From: David O'Connell
To: [Michelle Niles](#)
Subject: RE: Notice of Modification Request - Casuarina Town Centre Project Approval (MP 06_0258 MOD 12)
Date: Thursday, 11 October 2018 2:43:30 PM
Attachments: [image004.png](#)

Following on from the below, Council staff have reviewed the Casuarina Town centre MOD 12 application and have provided the below comment for consideration/clarification;

The proposed Mod appears to relate to car park lot (36) located on the eastern side of Casuarina Way (area of 928m²), which was amalgamated by mistake. The applicant is seeking consent to re-instate the lot as a separate lot.

| DRAWING TITLE:<br>SERVICES CONNECTIONS |                      |                         |                      |           |

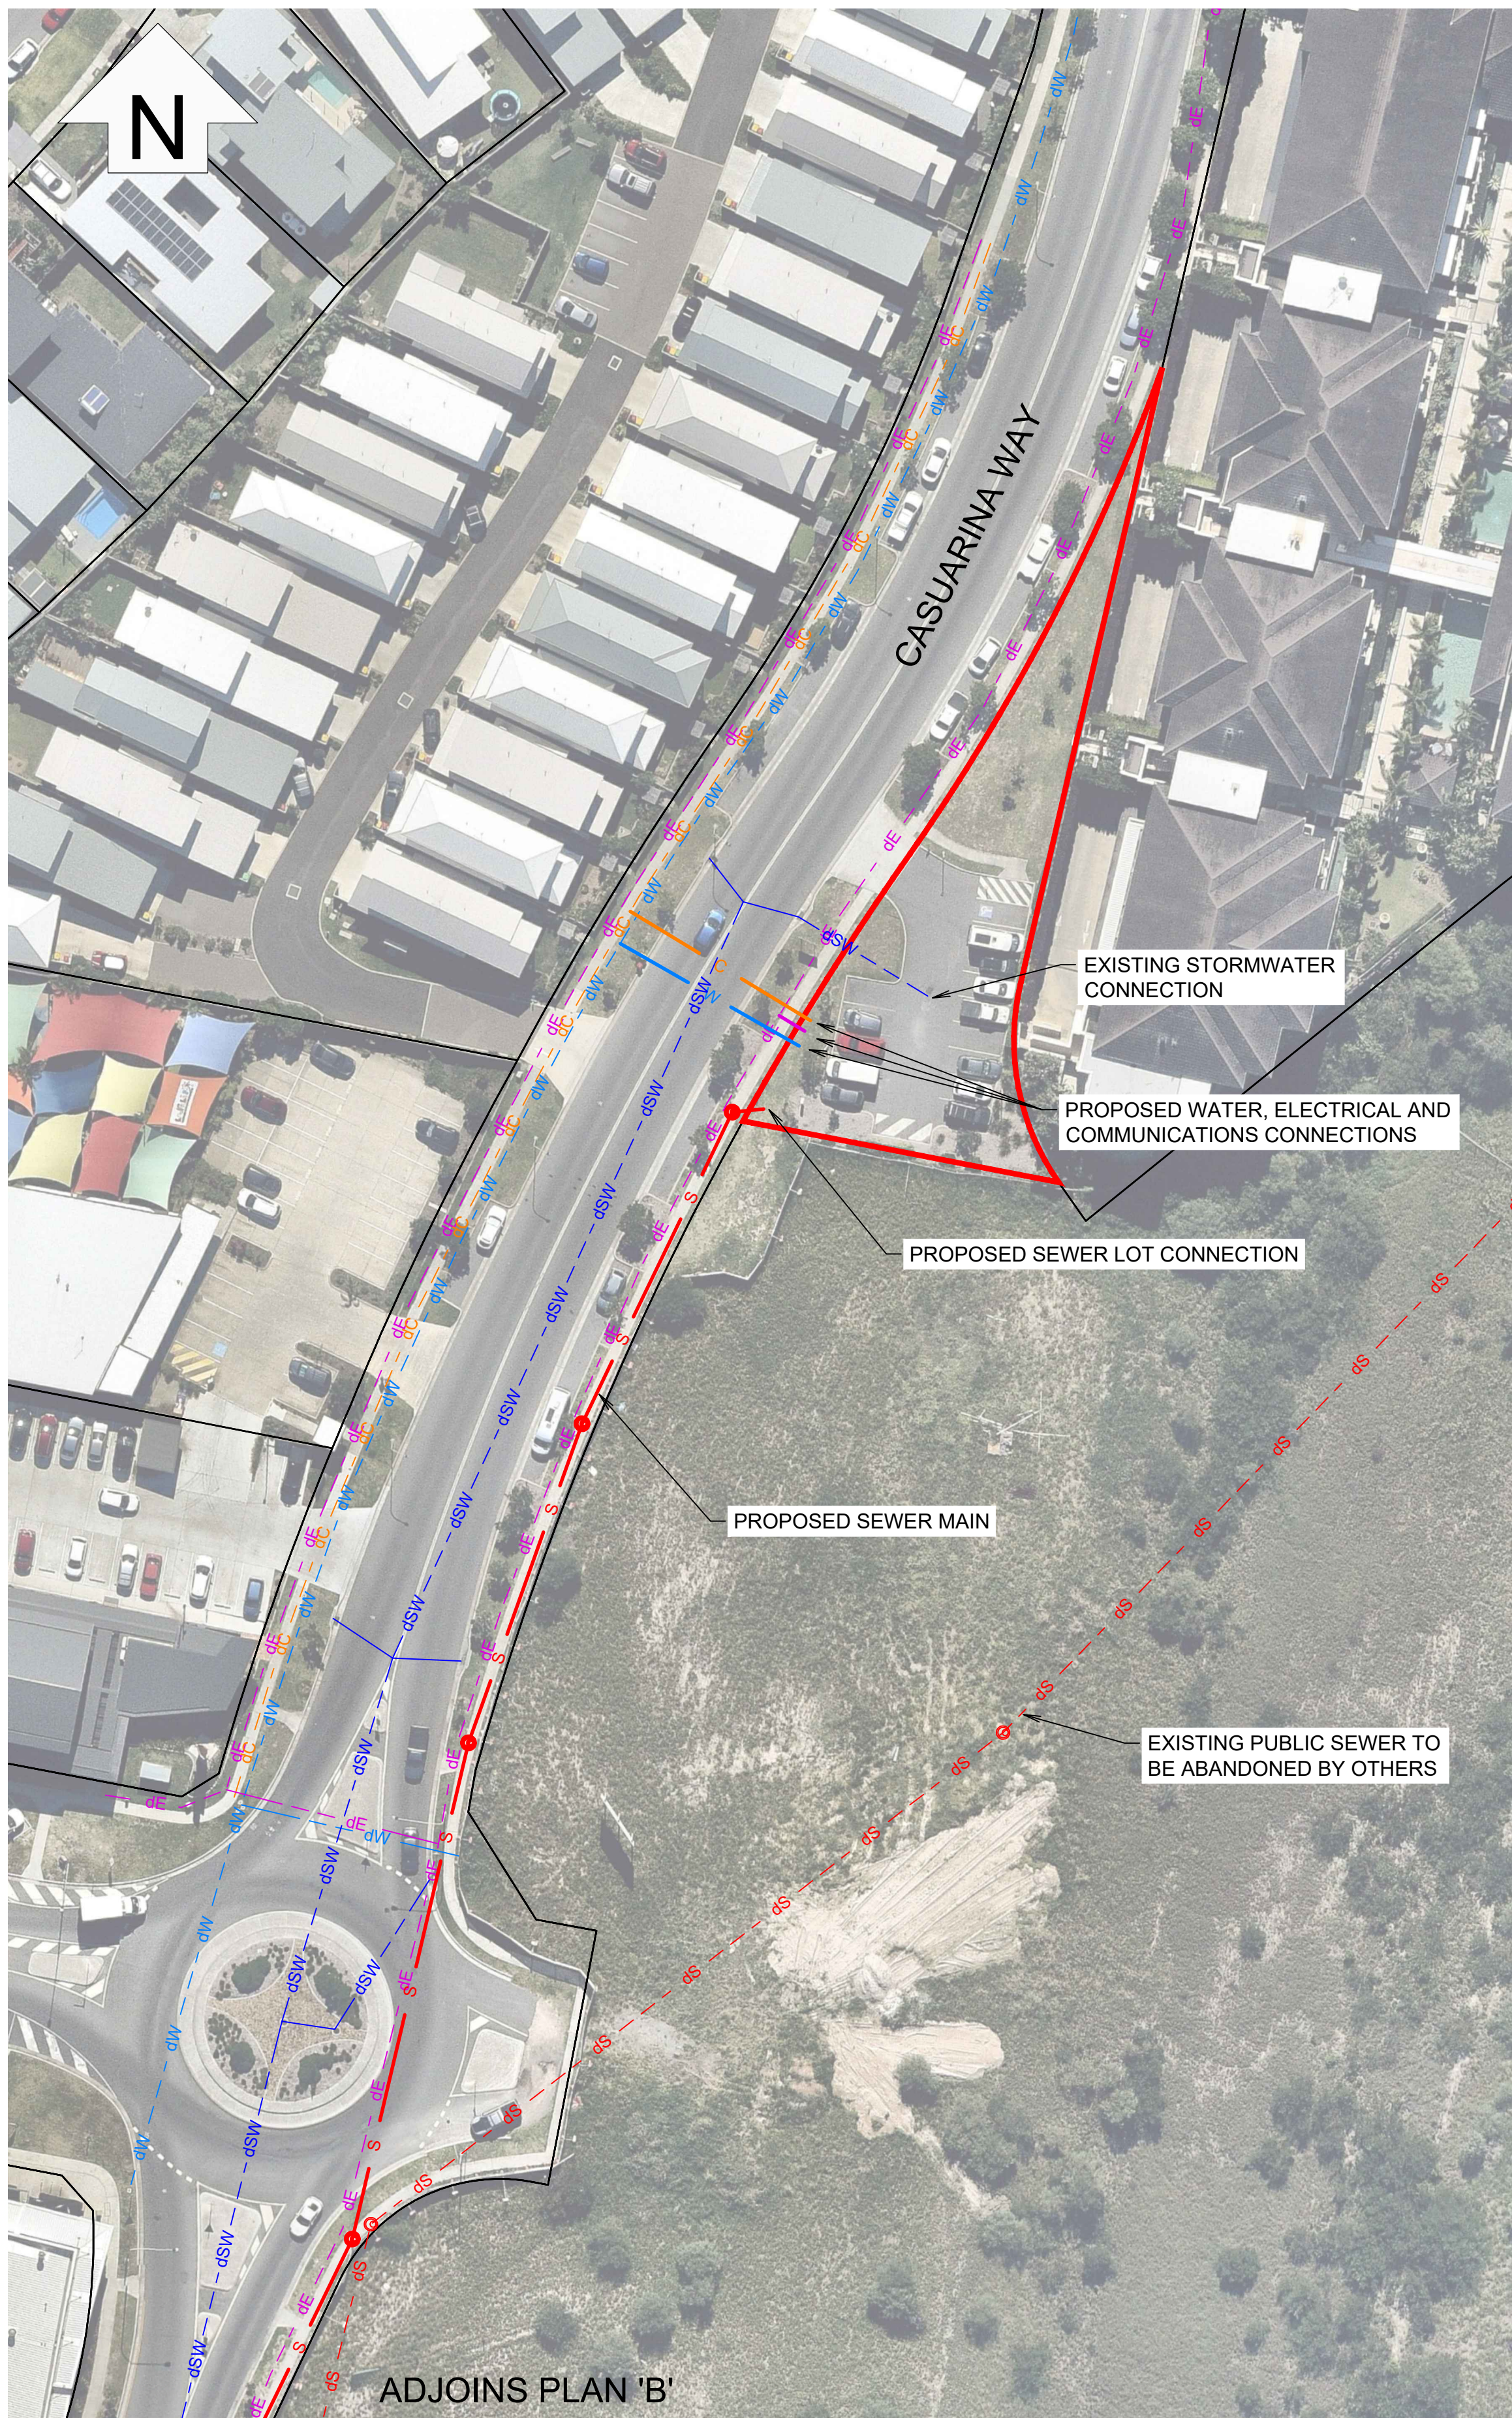
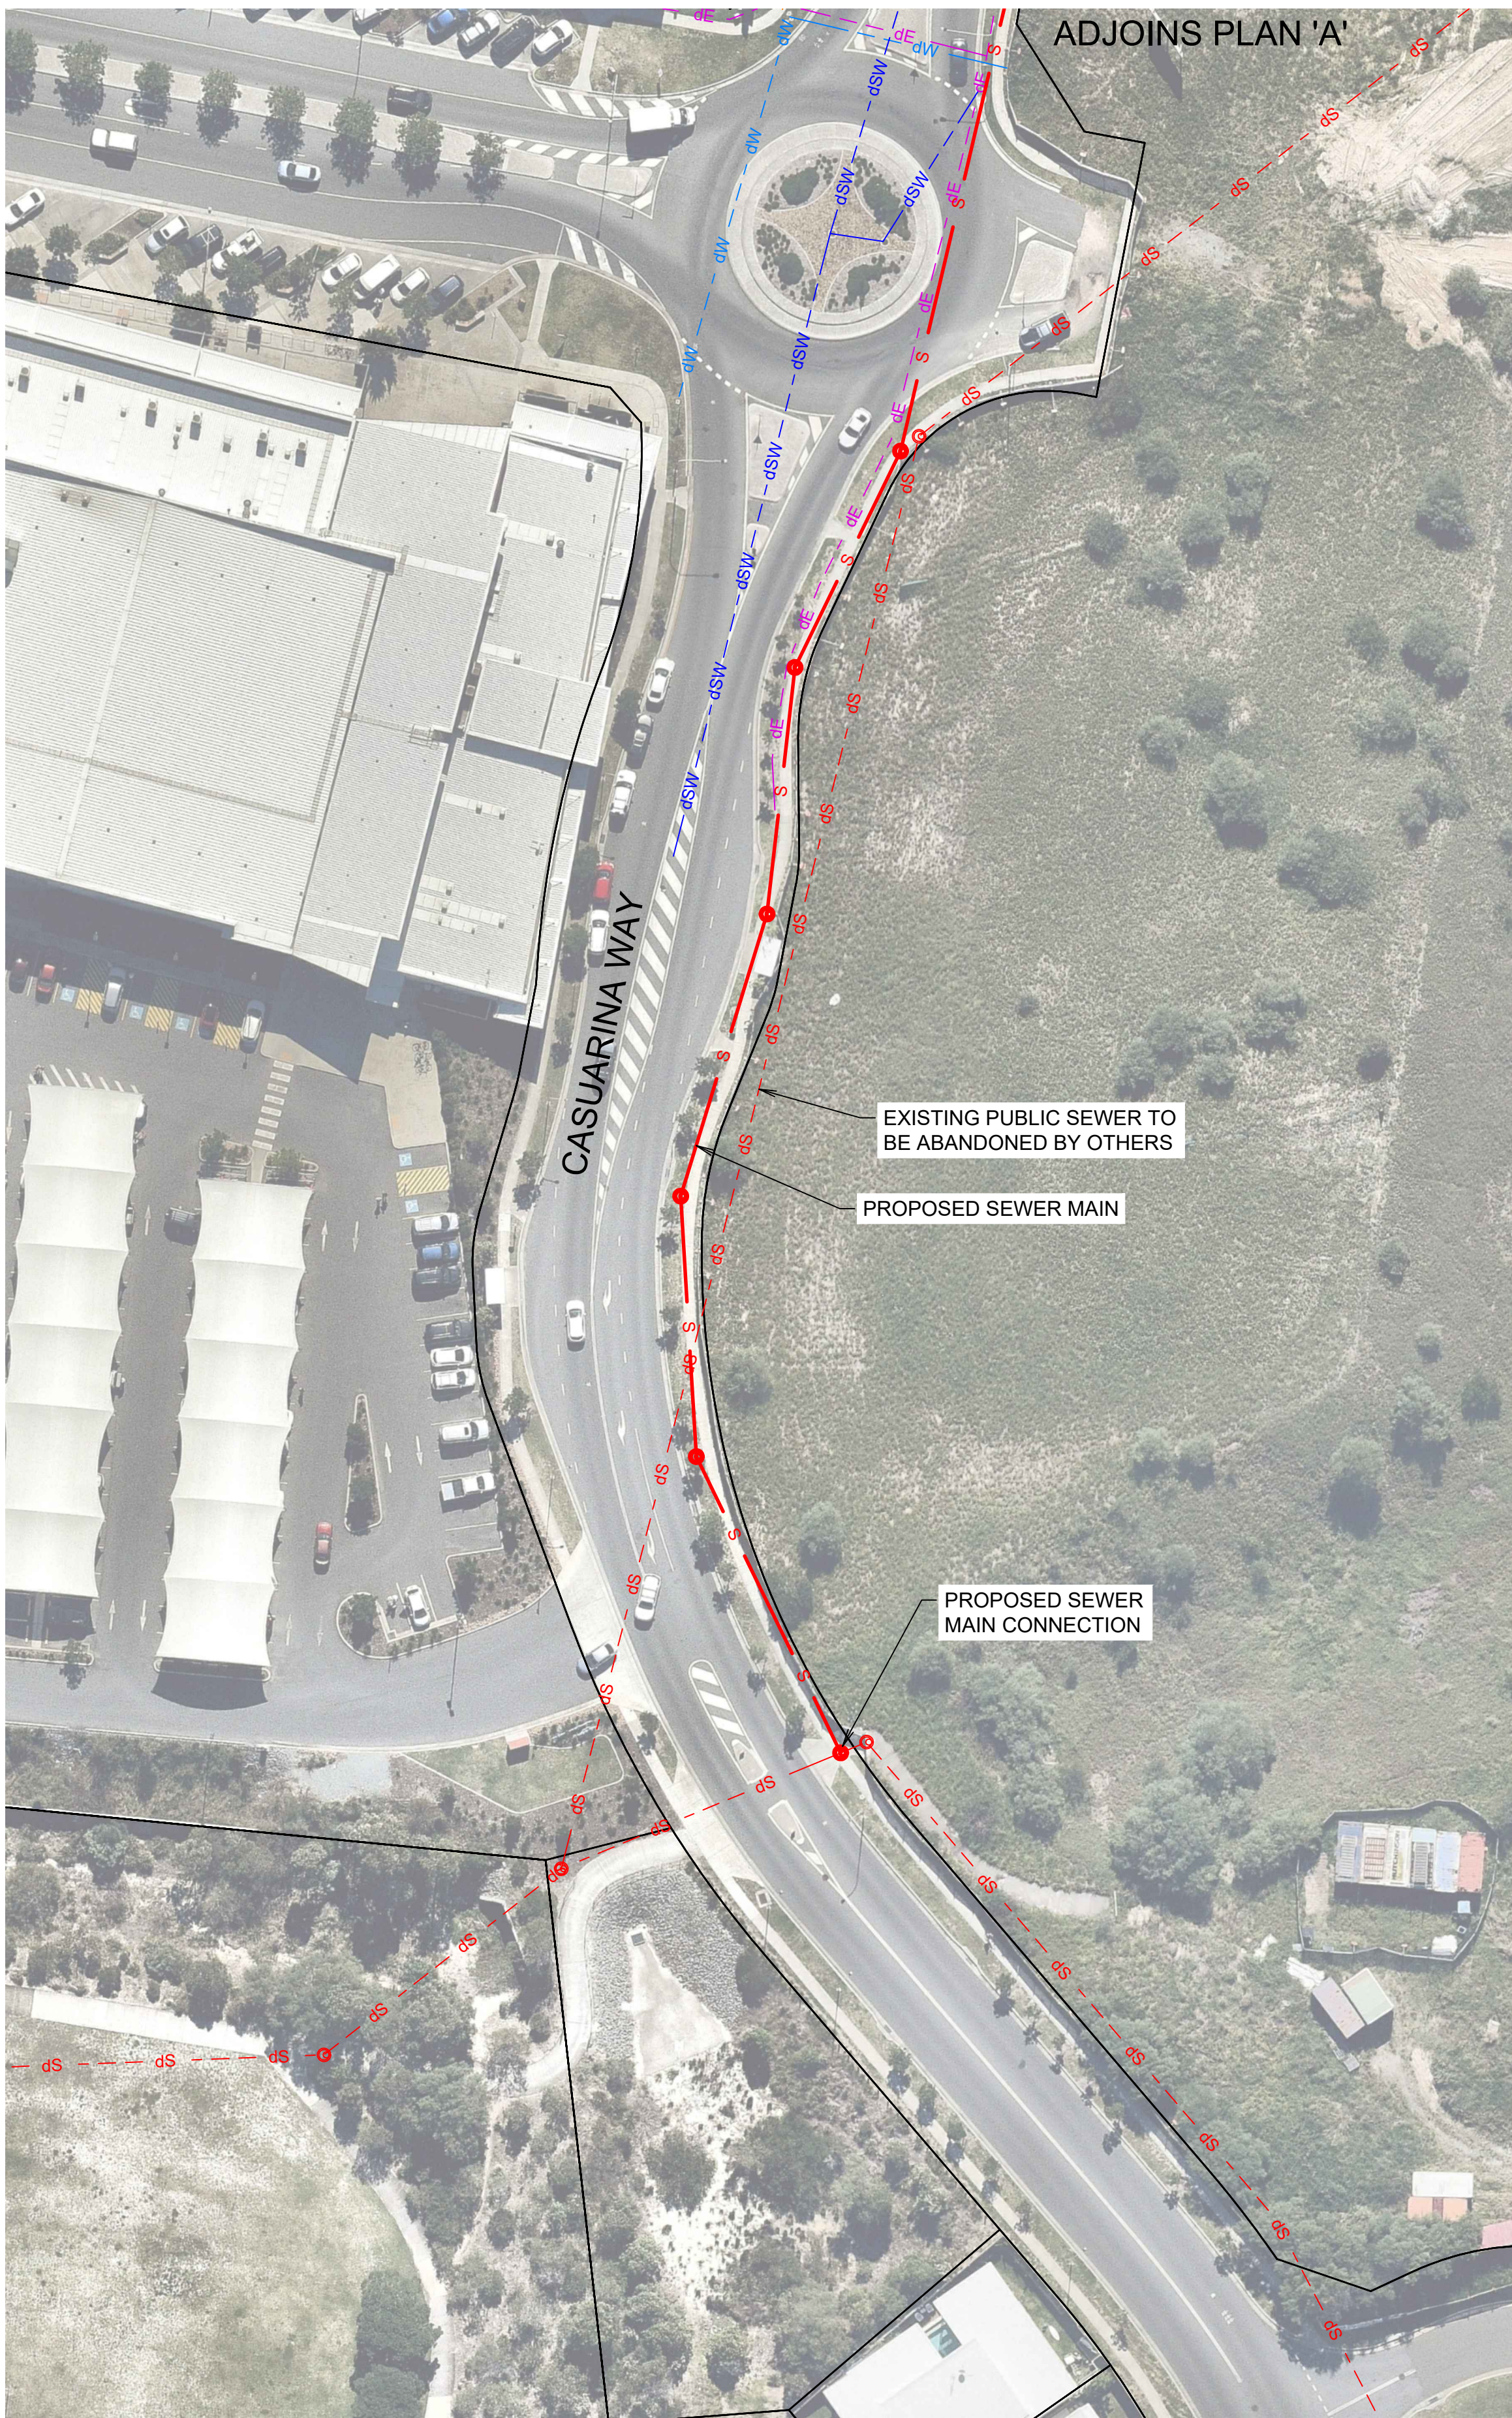
a) Water - Council's reticulated potable water supply is available to the area. Given the possibility of dwelling construction it is recommended that the developer demonstrate water connection to the proposed car parking parcel Lot 1.

b) Sewer - Council's piped effluent disposal infrastructure is available within the area, however it is not readily accessible for the car parking Lot 1 as the sewer is located some distance away in the form of a 225mm Sewer Trunk Main. Currently there is a previous modification over this site which seeks to relocate this trunk main.

Given the possibility of dwelling construction it is recommended that the developer demonstrate how the site will be connected with sewer to the proposed car parking parcel being Lot 1.

3. The developer to demonstrate all other service provisions can be provided to the car parking Lot 1 such as electricity supply, gas and telecommunication infrastructure, as applicable.
